PLANNING CONSULTATION RESPONSE

Application No	2026/0232
Proposal	Erection of 119 dwellings, open space and associated infrastructure.
Address	Land to the south of Bloomhouse Lane, East of Woolley Colliery Road, Darton, Barnsley
Date of Consultation Reply	21/05/2026
Consultee	Katie Lawrence, Planning Ecologist

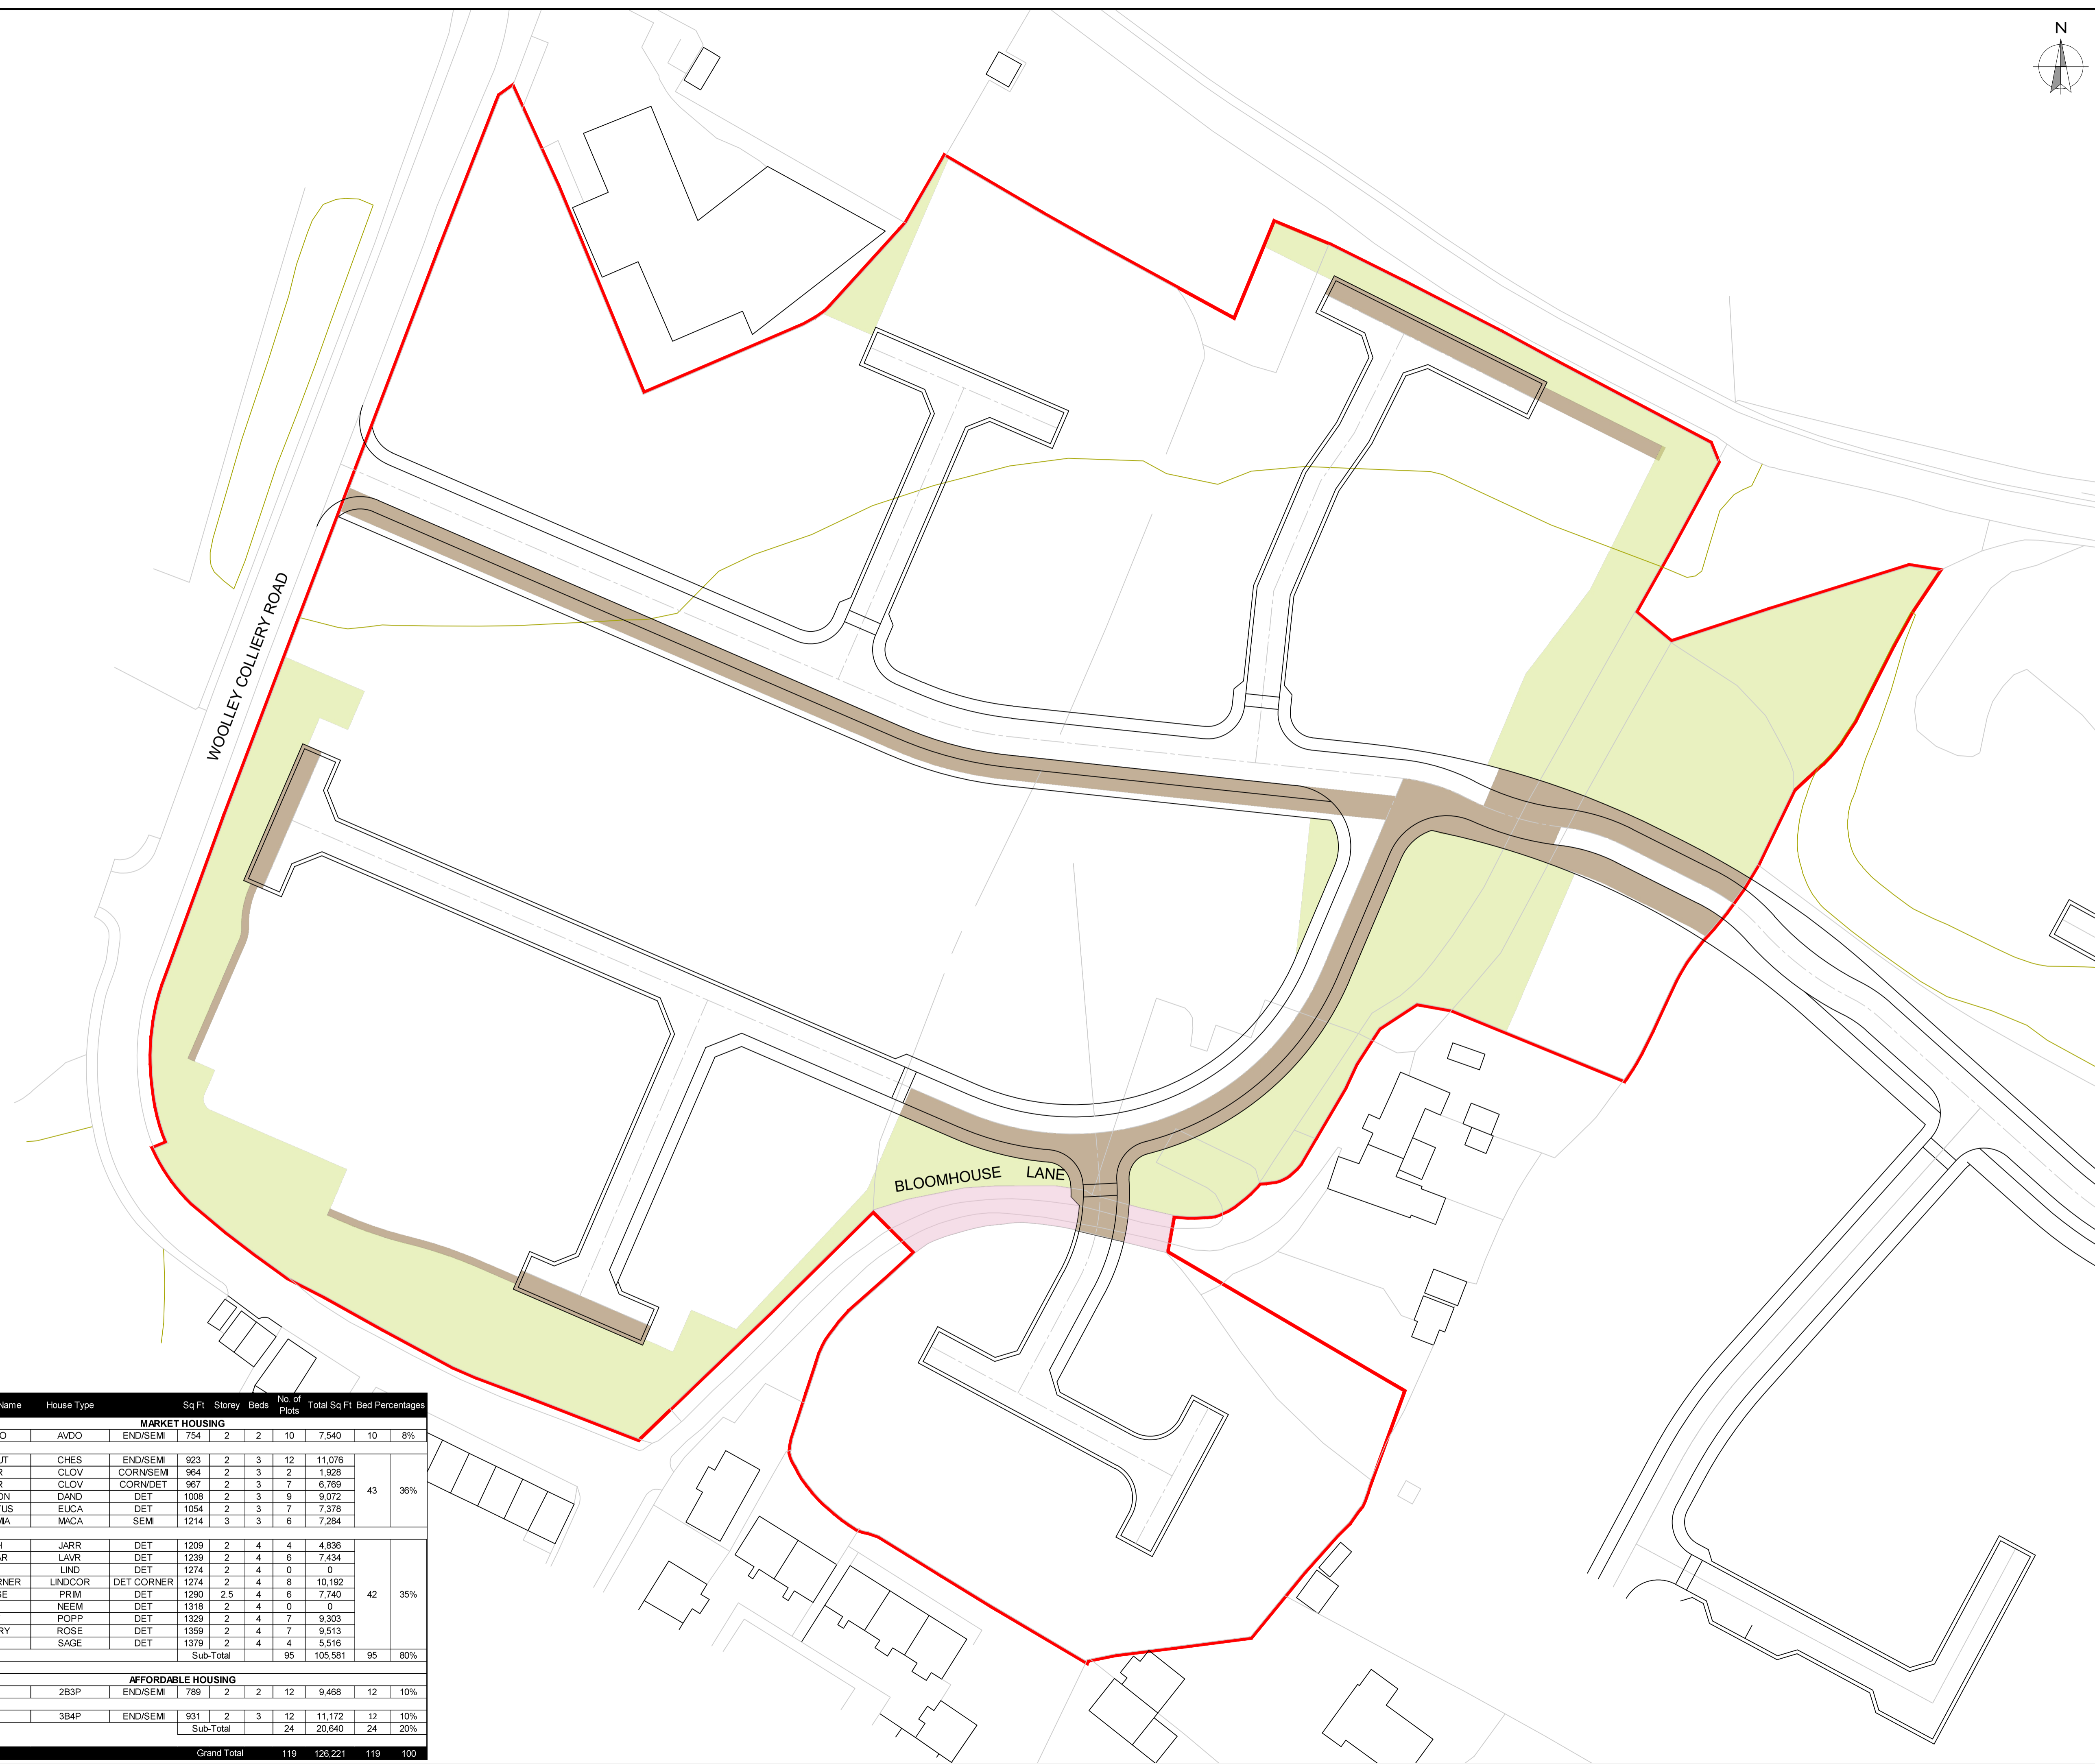
- Figure 2 of the BNG report sets out the proposals; these don't appear to match that which is set out within the site layout plan, so this requires amendment. Figure 2 and the metric submitted indicates a SUDS basin to the south-east corner of the site. The site layout plan shows that surface water attenuation tank is proposed in place of a SUDS basin. A SUDS basin would be preferable offering more opportunities for biodiversity and consideration should be given to the provision of SUDS in place of the attenuation tank.
